City of Albuquerque Stormwater Construction Site Inspection Report

| ESC File No. | C10E001A | Project Name: | Sonata Green | | |
| NPDES Id. No. | NMR1003AC | Location: | Tree Line Ave. and Universe Blvd. | | |
| Construction Phase: | Grading | | | | |

ESC-1

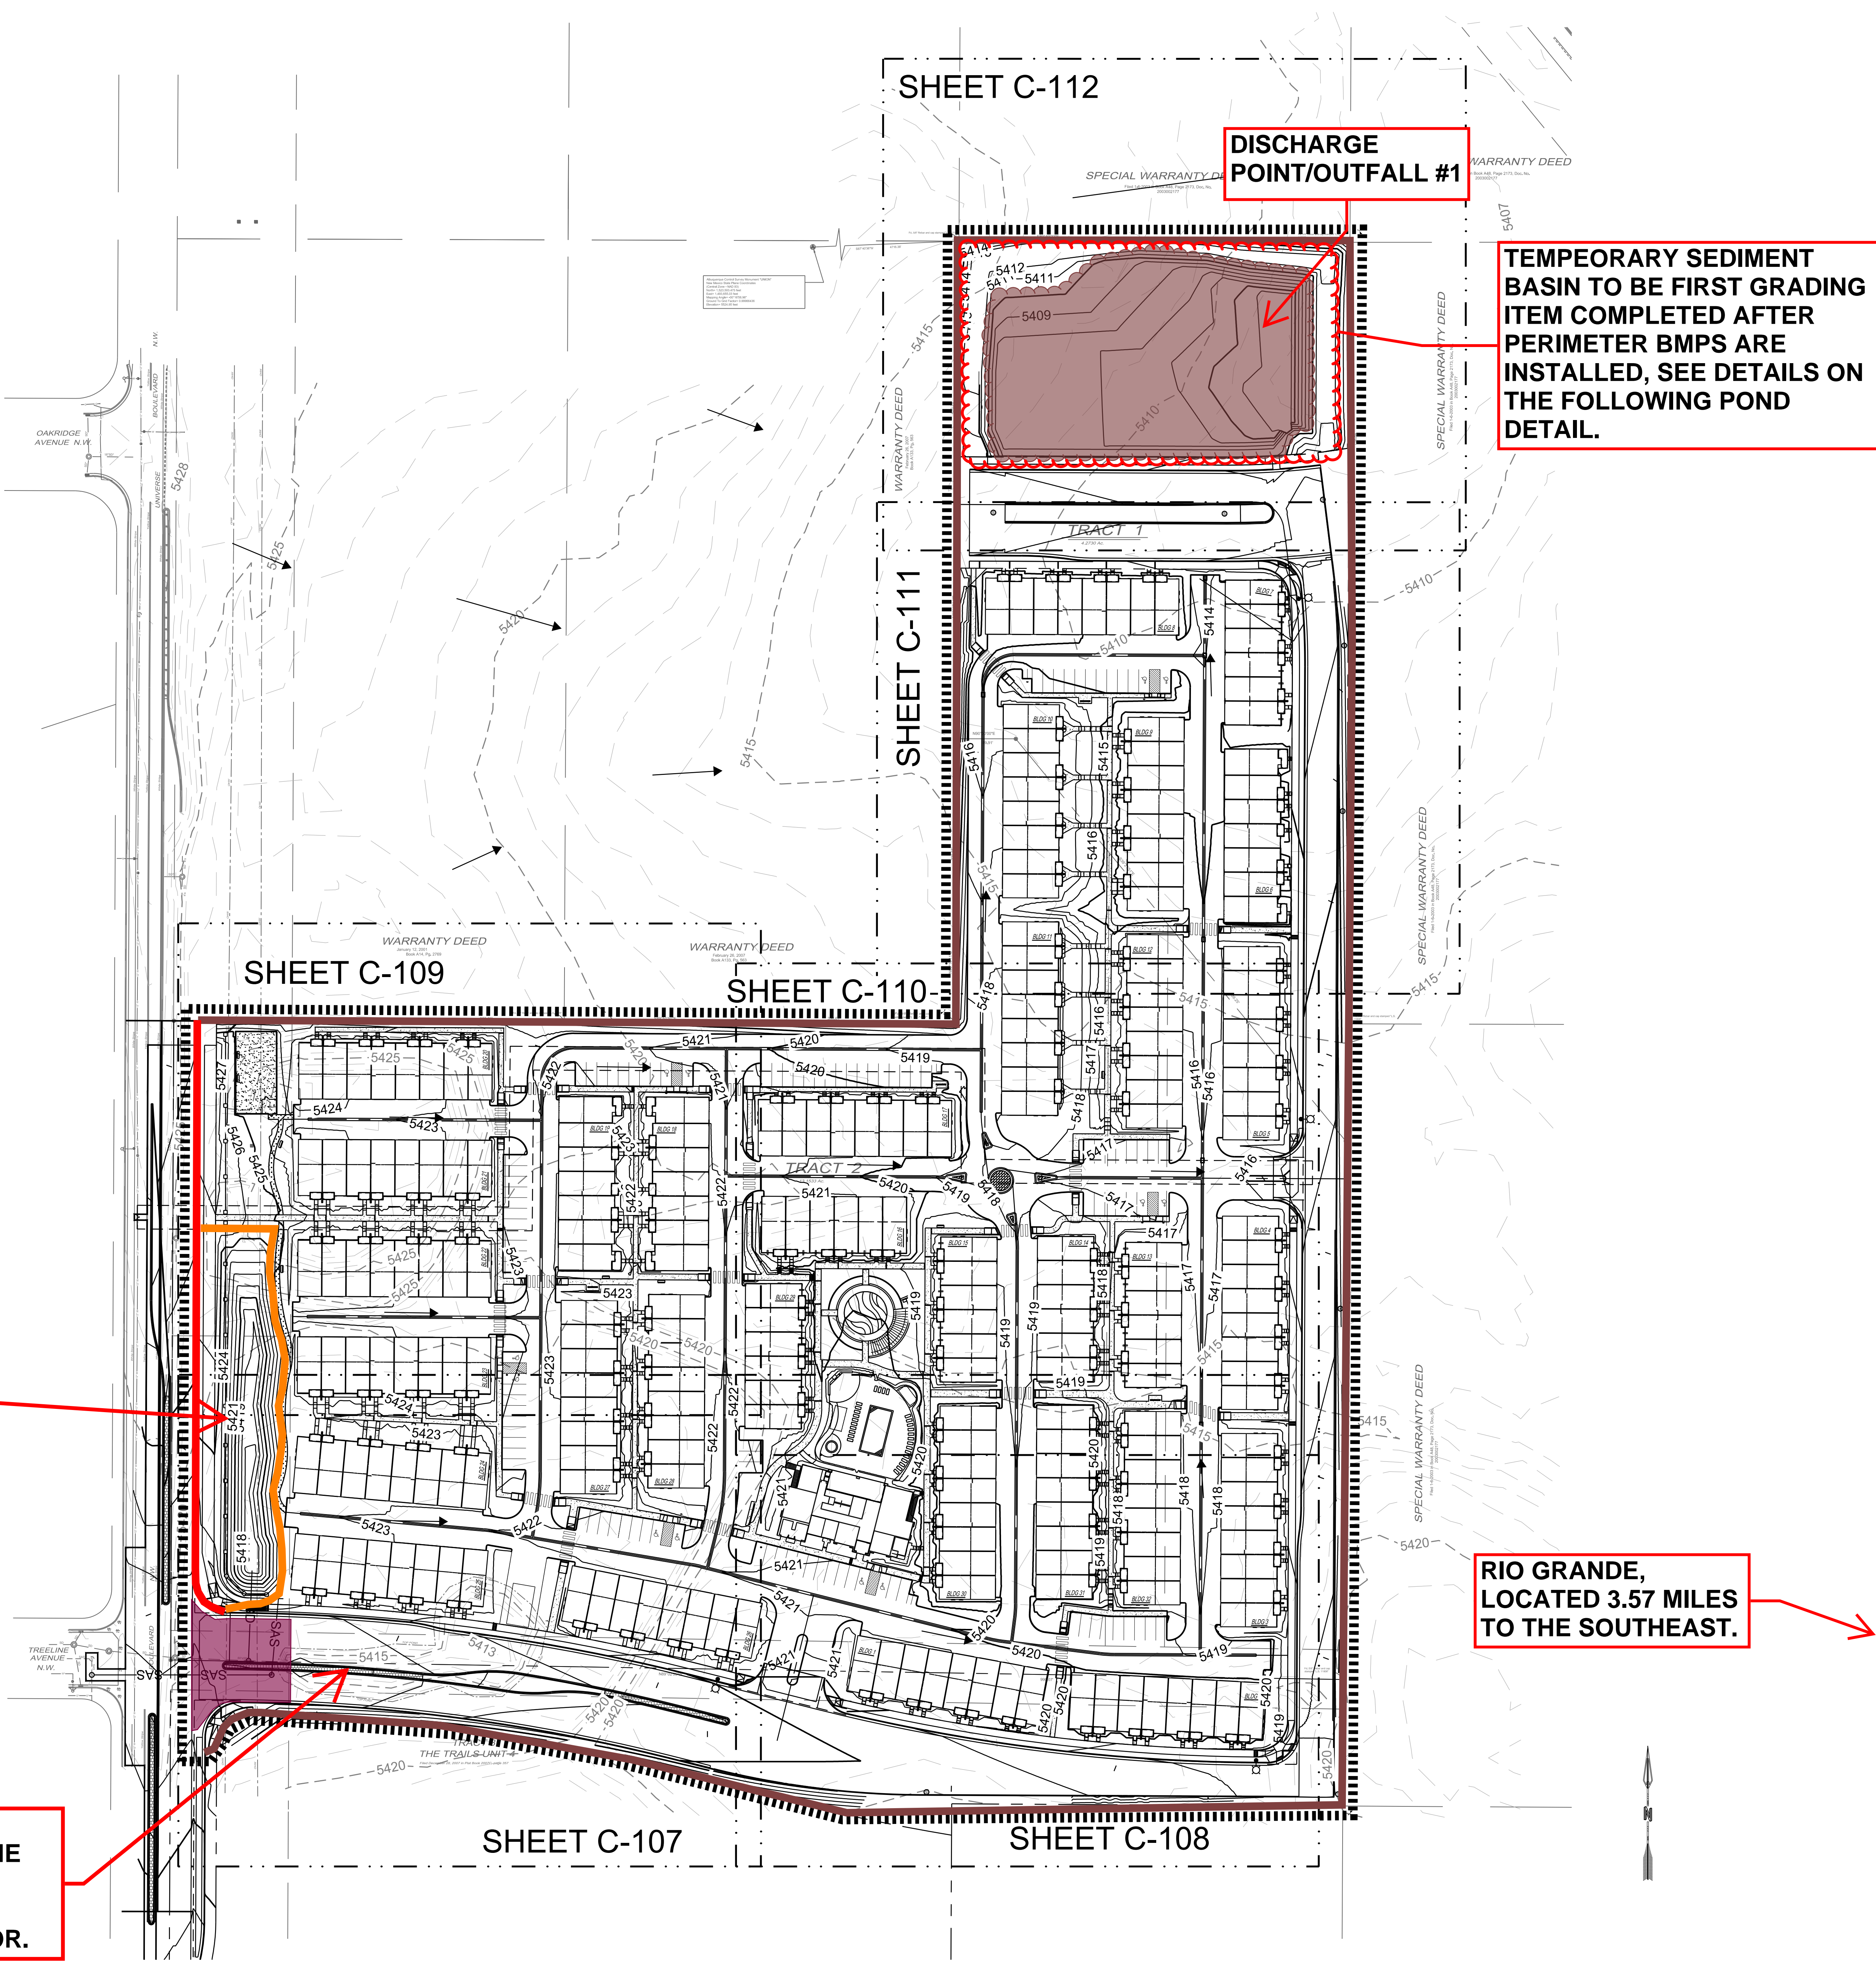
| Item Number | Deficiency/ Corrective Action | | | | |
|-------------|---|-----------|---------------------|------------|--|
| 1 | SWPPP map not up-to-date, offsite disturbed areas north and south of this site are part of this common plan of development. Required Mitigation: Offsite limits of disturbance and a stabilization specification must be added to the map. The SWPPP, including the Map, the NOI, Self Inspection Reports and Corrective Action Reports, must be kept up-to-date per CGP 7.1 and available on-site per CGP 4.7.3, 5.4.3 and 7.3. | | | | |
